**From:** Martin Szczerbicki [REDACTED]  
**Sent:** 17 December 2014 16:58  
**To:** juan.beaza@arun.gov.uk  
**Cc:** Daun Johnson  
**Subject:** 3 High Street, Littlehampton, BN17 5EG  
**Attachments:** Drwg. 14.01.035F F4 Blue outline.pdf; Drwg. 11321679A F4 Blue outline.pdf

Ref PP - 03842199 3 High Street, Littlehampton, BN17 5EG

Further to our telephone conversation today we enclose A3 copies of drawing No.1132/1679A approved under LU/92/13 and drawing No. 14.01.03/5F for approval as non material amendments to the original approval, both marked up in blue outline showing the parts of the building affected by the application and with amendment items numbered 1 to 6 and described below.

Planning Drawing
14.01.085F
1/60
4/2014
A1

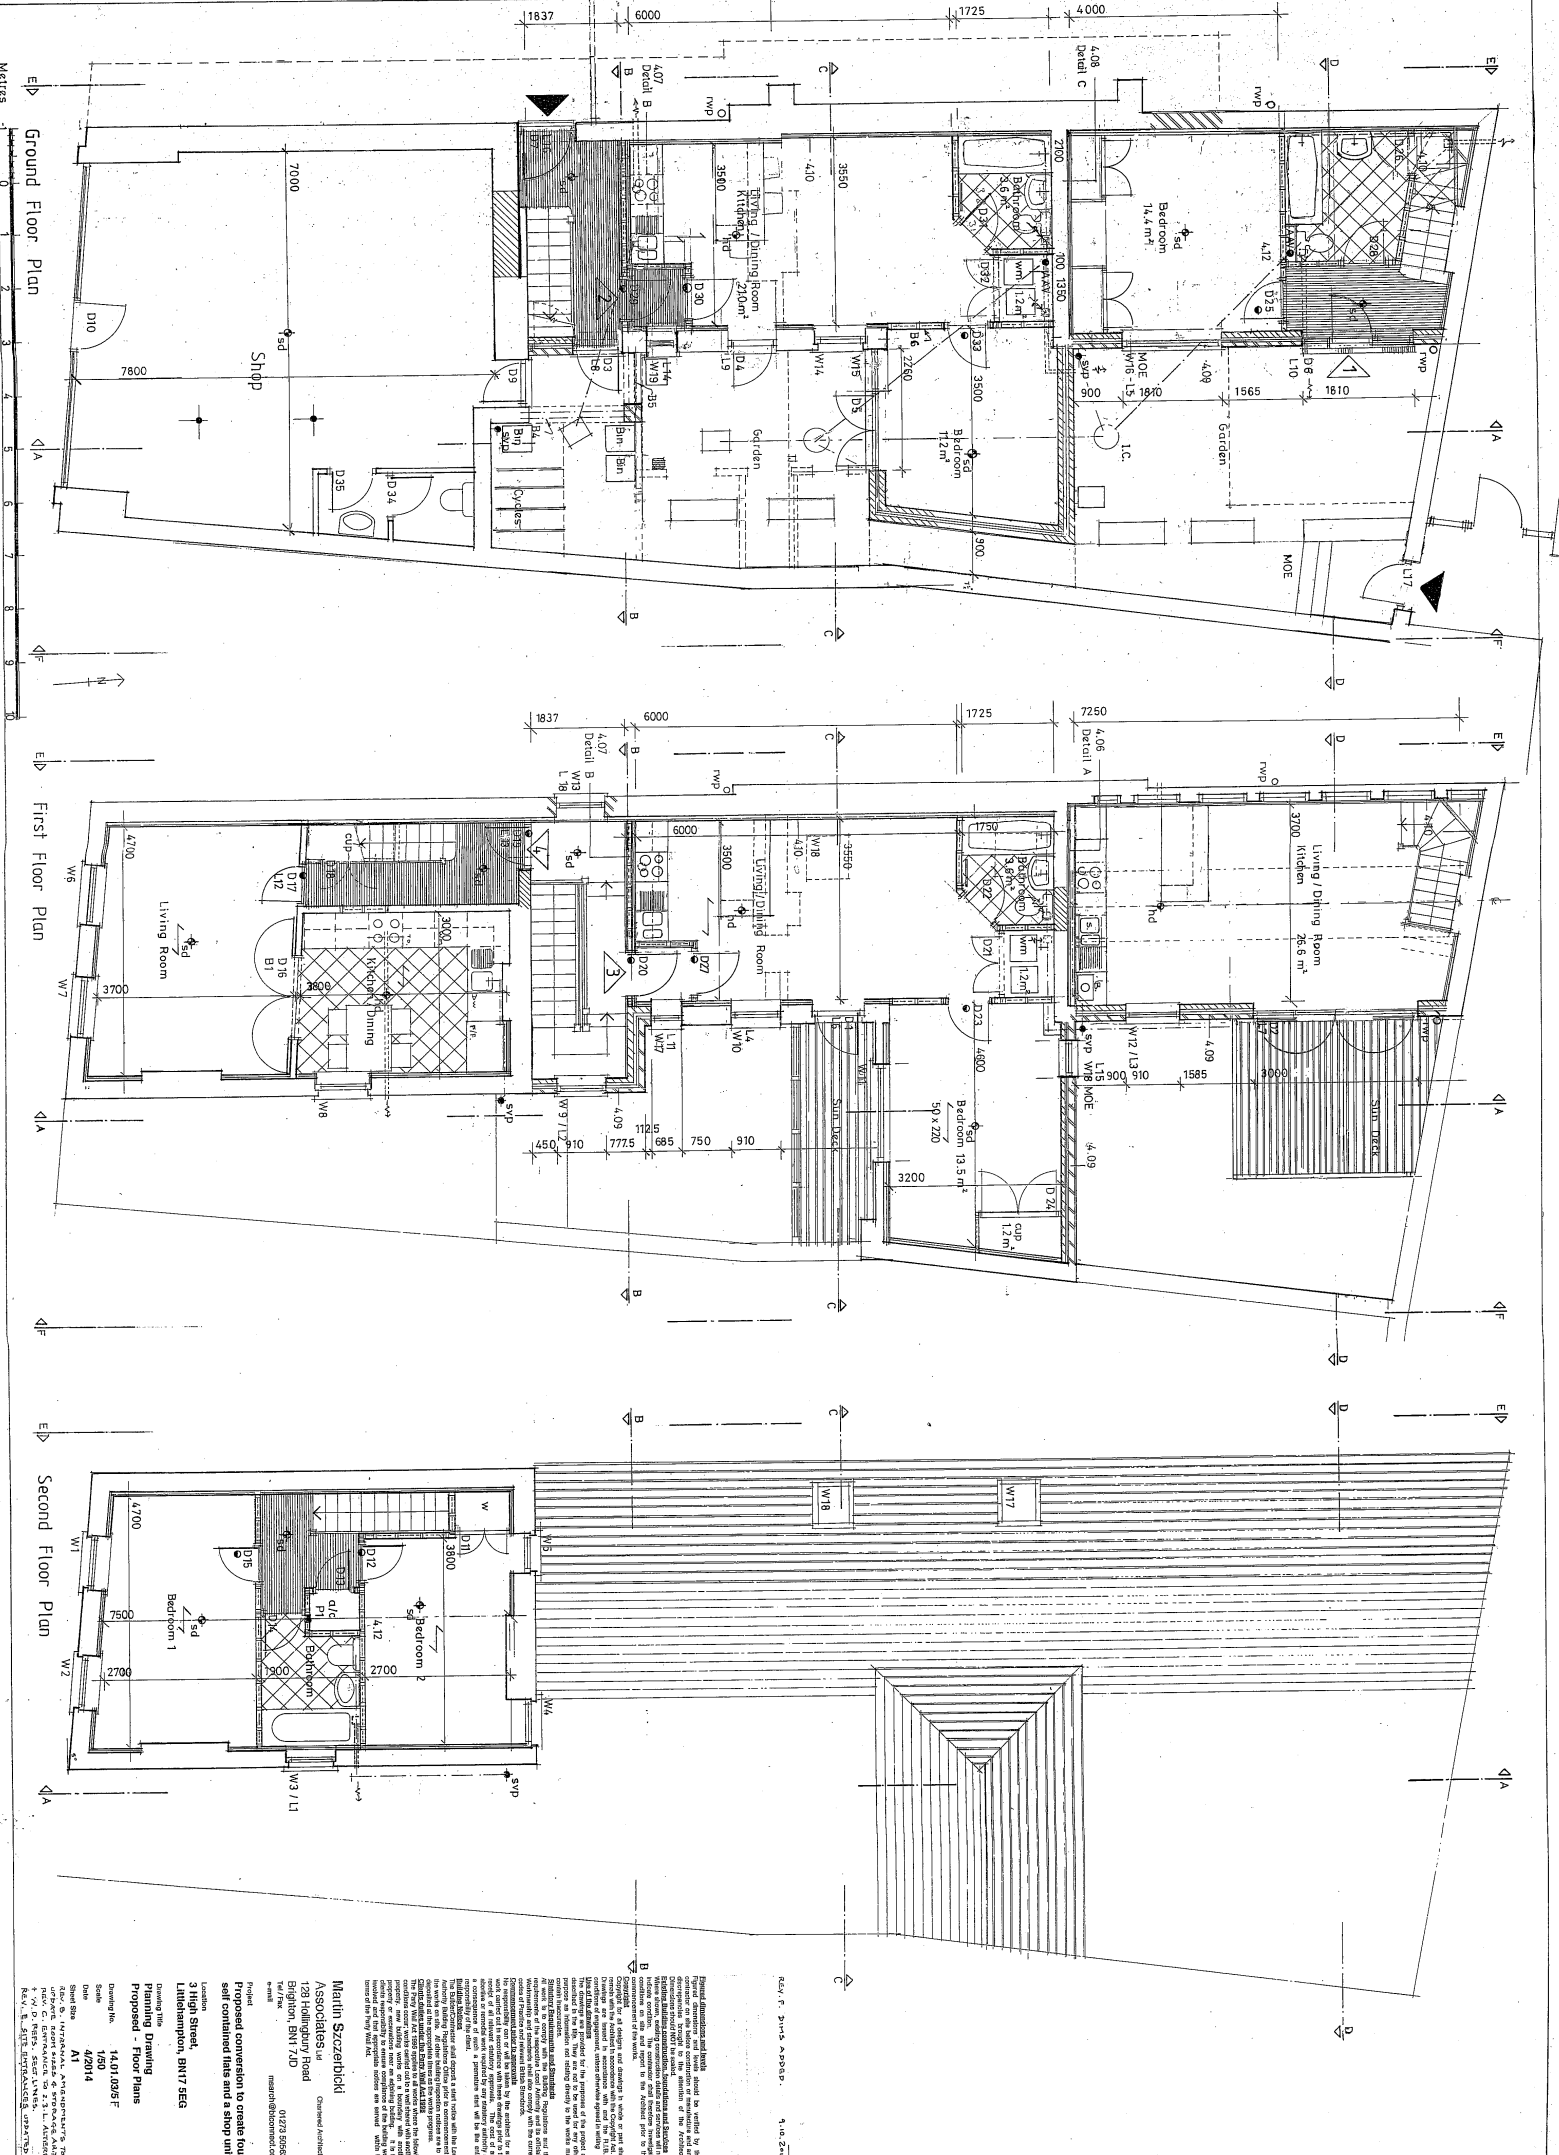
1. Timber enclosure to be removed, door opening infilled with wall panel and window.
2. Internal layout to be changed from three bedrooms to two bedrooms and a bathroom.
3. Internal layout to be changed from bathroom, living room and kitchen to, a kitchen / dining room and living room.
4. High Street Entrance removed and replaced with entrance to the back of the unit.
5. Bathroom window added to east elevation at second floor.
6. Existing window removed and replaced by a solid wall panel and two windows.
